**CITY OF PORTLAND**

This is to certify that Bryan Dean & Company Inc., Charles  
has permission to New prefab 28' x 52' single family home  
at 634 Main St., Portland,

449 Congress Street, 04101 Tel: (207) 874-8700, Fax: (207) 874-8716		Permit No:	Issued Date:	CRIS:
Landowner or Contractor:	Owner Name:	Owner Address:		
71 Frost St.	Bryan Dean D &	361 Bay Pointe Cir		
Address Name:	Contractor Name:	Contractor Address:		
R/V:	Malec Home Charlers	4 Oxford Home Lang Oxford		
Responsible Person's Name:	Phone:	Permit Type:		
n/a	614	Single Family		
Proposed Date:	Proposed Project Description:			
	New pre-fab 28' x 52' single family home, address 71 Frost St.			
	71 Frost St. New pre-fab 28' x 52' single family house.

111 RUST STREET  
CHECK-LIST AGAINST ZONING ORDINANCE

MINOR SITE PLAN For: A PROPOSED LOT SPLIT 71 FROST STREET PORTLAND, MAINE	
FOR:	DEAN D. BRYAN

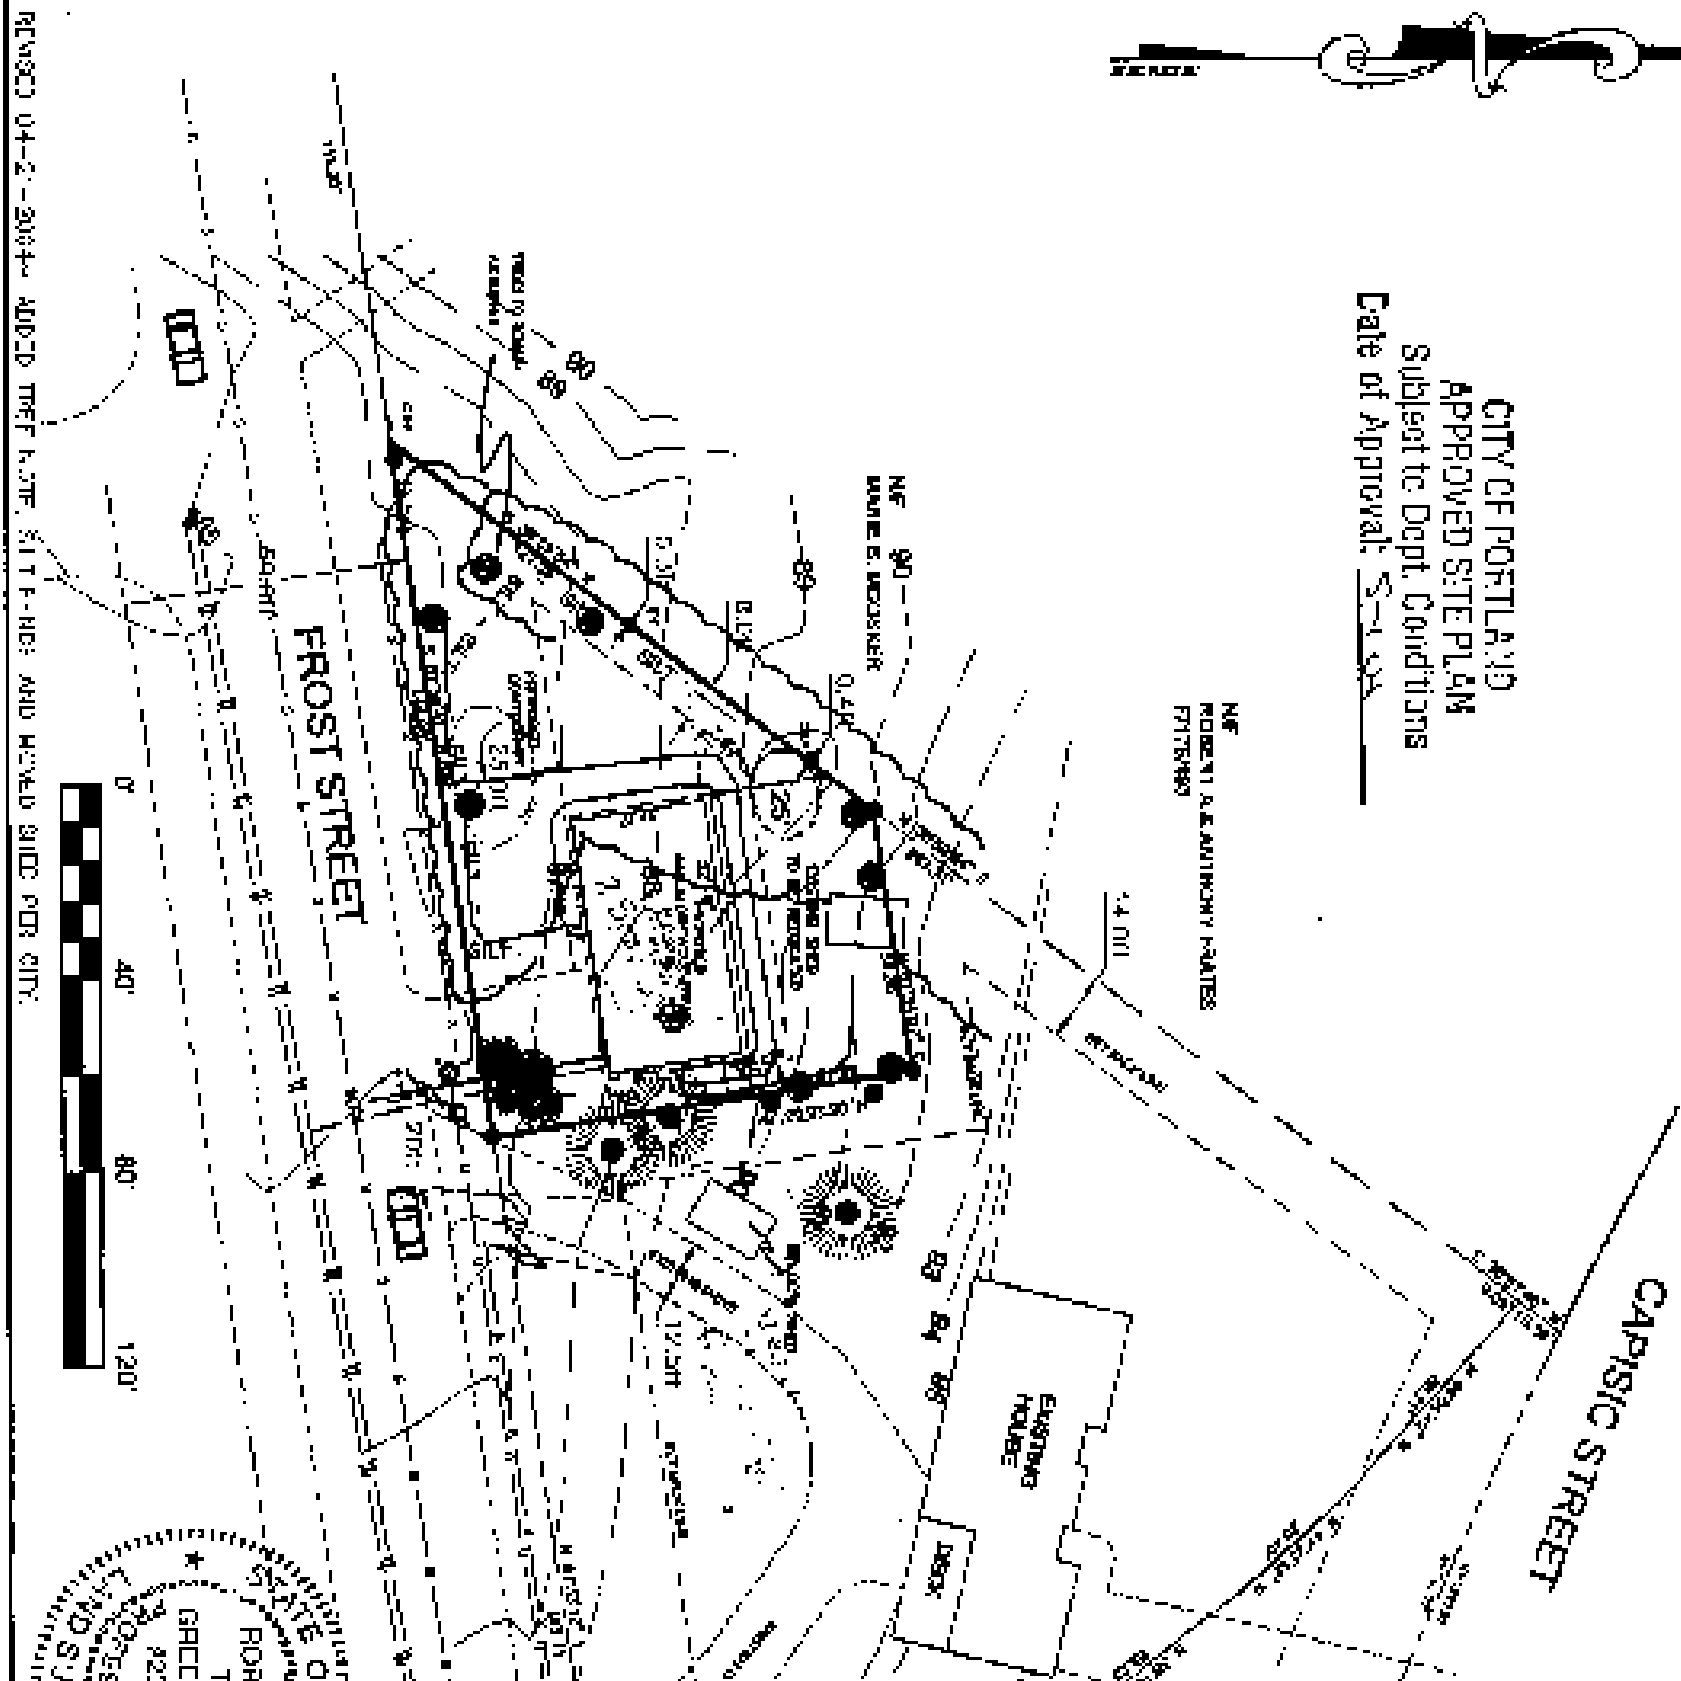
3/14/04 received revised plans for setback that will have questions on front bay window - I called Dan Greenlaw and he stated that the building is planned so that the front bay window will be within the required 28' front yard setback.

- 1) It is requested from Dan Greenlaw that the front bay window NOT extend out into the required 28 foot front yard setback. Please note that any of your setbacks are exactly meeting the minimum requirements. The Code Enforcement Officer will need verification for these setbacks.
- 2) Separate permits shall be required for feature decks, x 10x8, porch, and/or garage. NO REAR DECKS are being shown on the submitted plans. NO REAR DECKS are approved in this permit.
- 3) This property shall remain a single family dwelling. Any change of use shall require a separate permit application for review and approval.
- 4) This permit is being approved on the basis of plans submitted and received on 3/14/04. Any deviations shall require a separate approval before starting that work.

Concerned about front overhangs; bkg  
window which can NOT open fully without

skirt shall be installed be no less than 8' from the side property
